Ribble Valley Borough Council
By email

Your ref 3/2022/0226
Our ref DC/22/1066
Date 05-MAY-22

Location: Dickinsons Farm Main Street Pendleton BB7 1PT
Proposal: Erection of a new building to accommodate a new parlour and dairy and associated concreting

Title: Existing Topographical Data, Existing and Proposed Site Cross Sections.	
Drawing No: SII/1031/3141/03	Drawn: PF
Client: K & A Slinger and Son	
Date: 17.02.2022	Scale: 1:200 @ A1
Amendments:

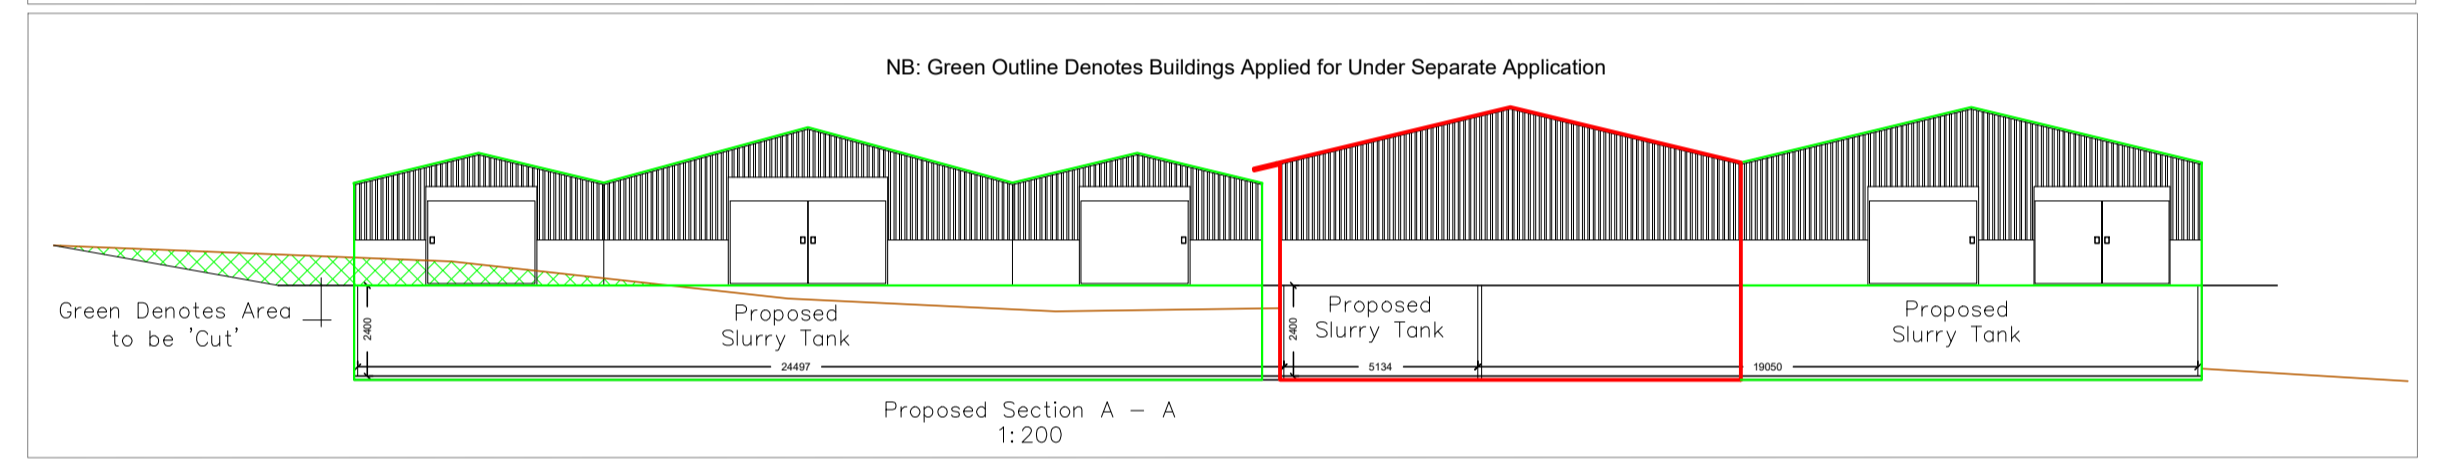
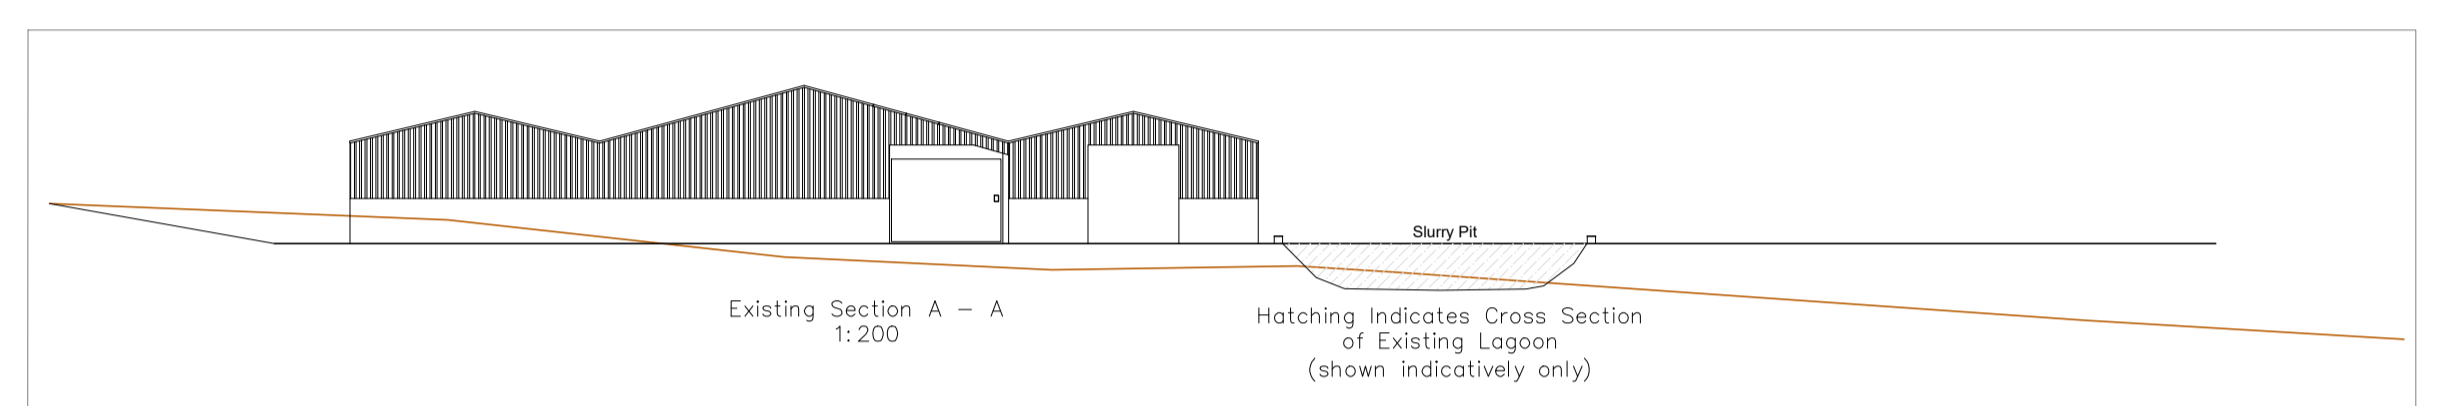
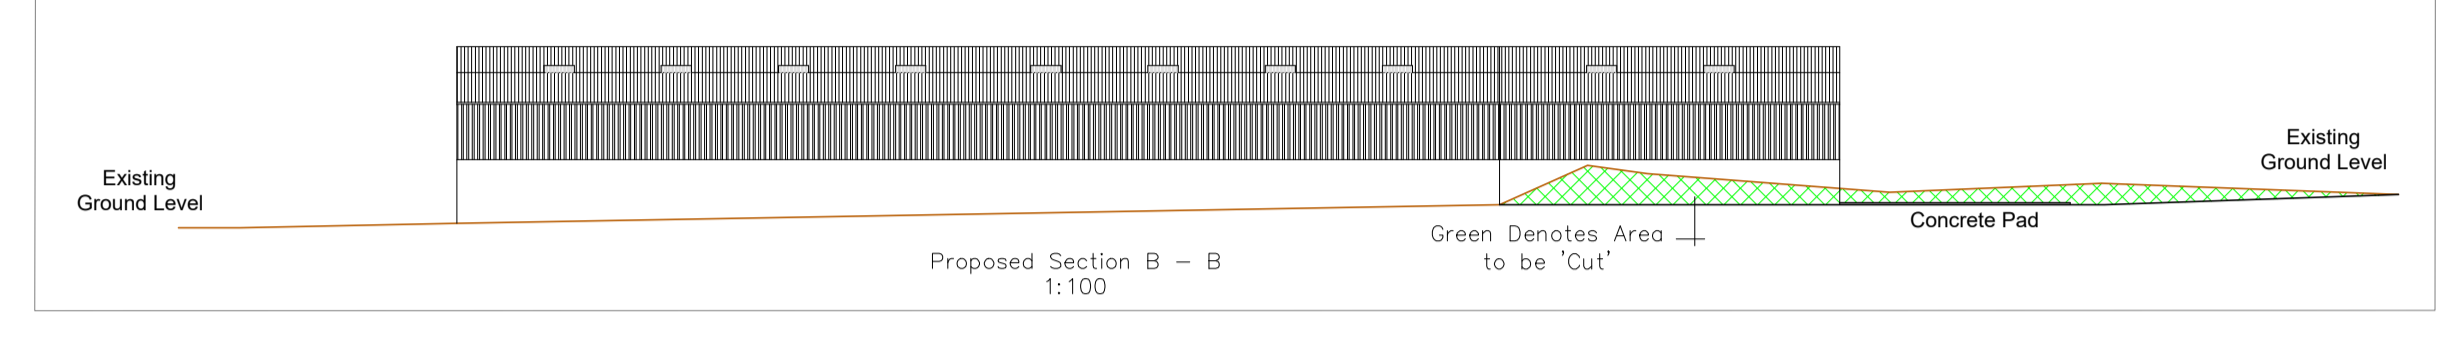
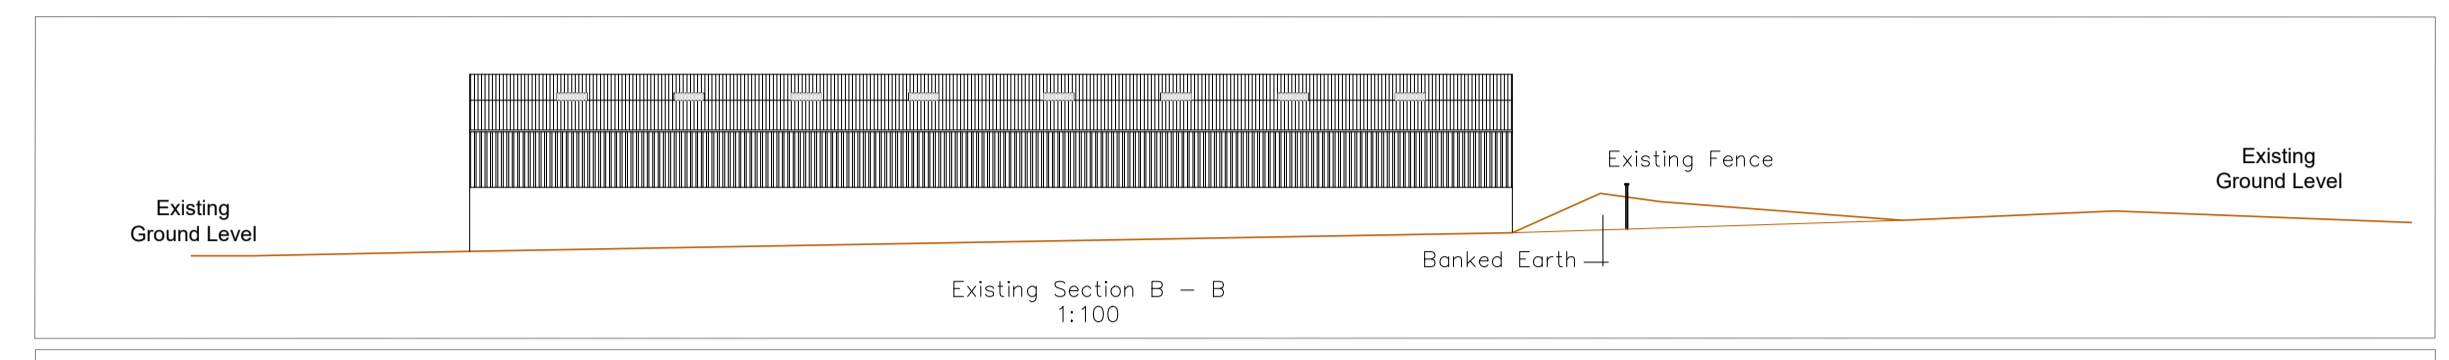
Following our review of the proposed site layout, we can confirm that the proposal is not acceptable to United Utilities as proposed features appear to be located above our water main. Until such time as the applicant has resolved all concerns regarding the proximity of proposed development to our water assets, our position is that we OBJECT to the proposal. To discuss the proposal in relation to the water main we recommend the applicant contacts Sara Livesey by email at DeveloperServicesWater@uuplc.co.uk

Should the Council deem this application suitable for approval without resolution of this matter, we request the following condition is included in the subsequent Decision Notice to afford appropriate protective measures for this asset:

No construction shall commence until details of the means of ensuring the water main that is laid within the site boundary is protected from damage as a result of the development have been submitted to and approved by the Local Planning Authority in writing. The details shall outline the potential impacts on the water main from construction activities and the impacts post completion of the development on the water main infrastructure that crosses the site and identify mitigation measures to protect and prevent any damage to the water main both during construction and post completion of the development. Any mitigation measures shall be implemented in full in accordance with the approved details.
